Your Ref: OWPC16910
Our Ref: FP/302/17/PL 04-12-2017
Please ask for:
Mr S Davis

19th January 2018

Outbuilding
10 Kingsmead Felpham

NOV 2017
1-100, 1-500
DRG 1A

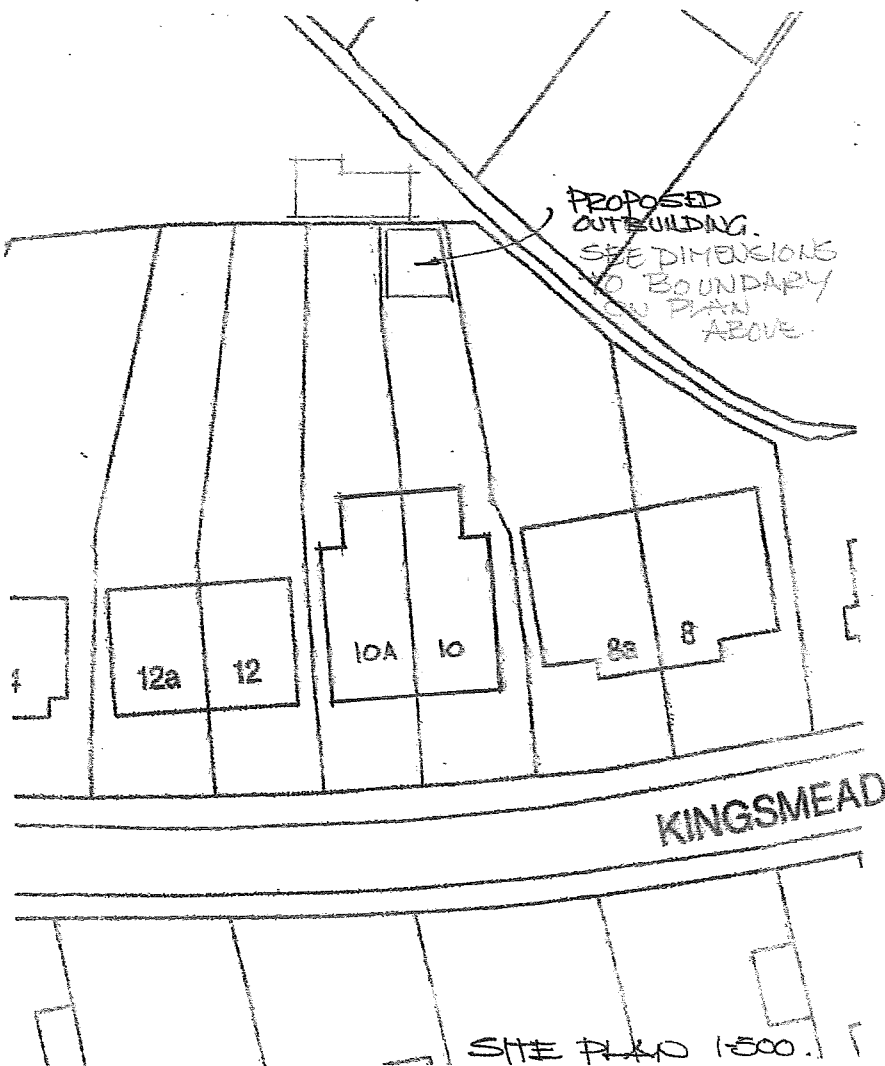
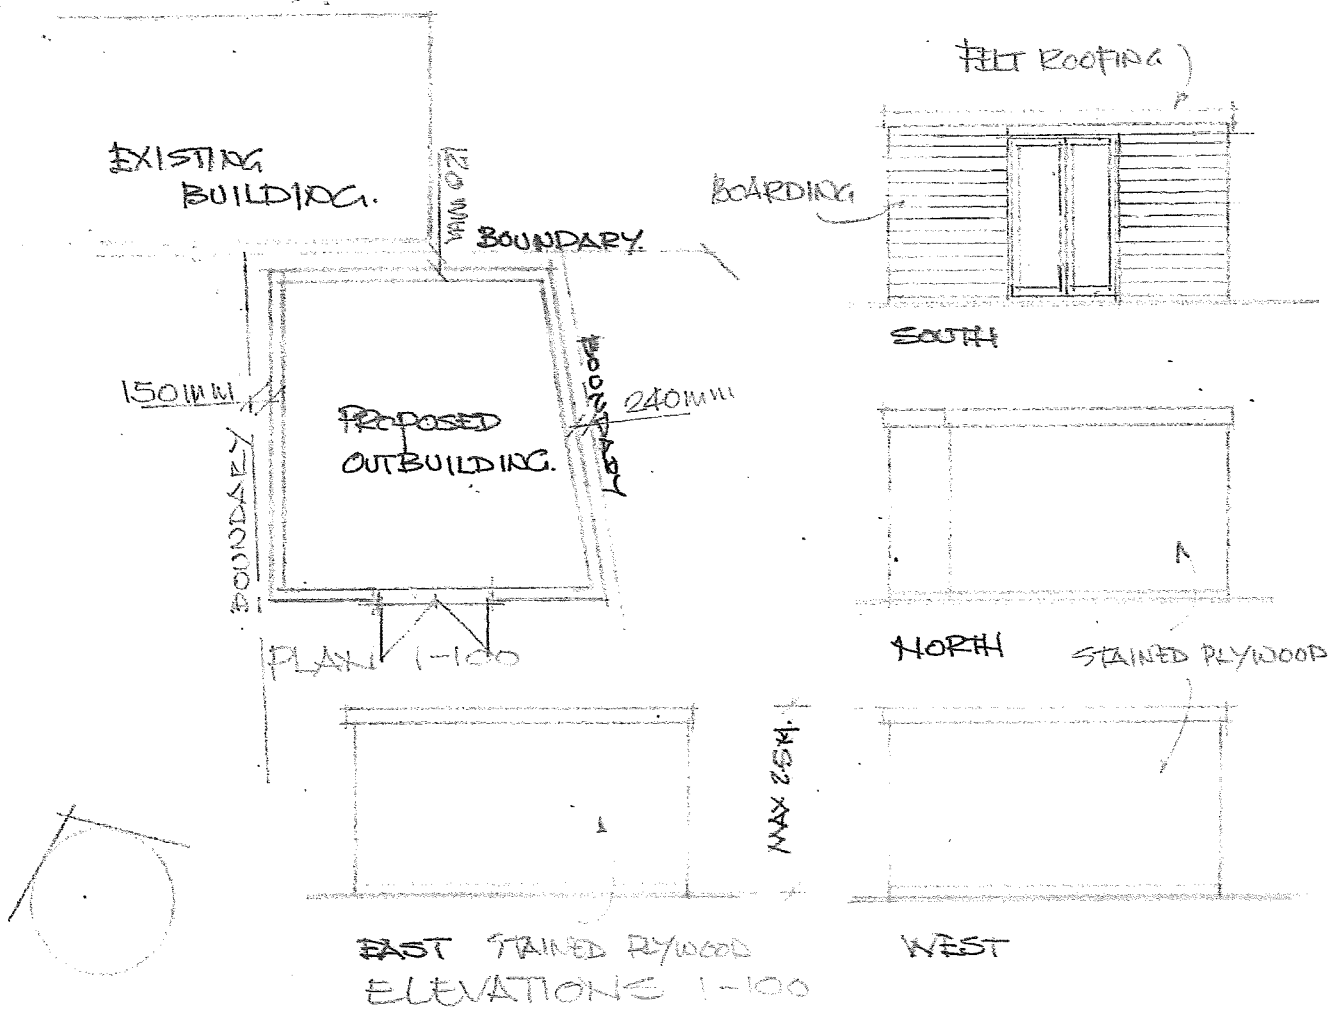
Object on the grounds that the dimensions are not clear as to the height and size of the building and the boundary to our fence looks very close on the drawings and there is power and water going in there too.
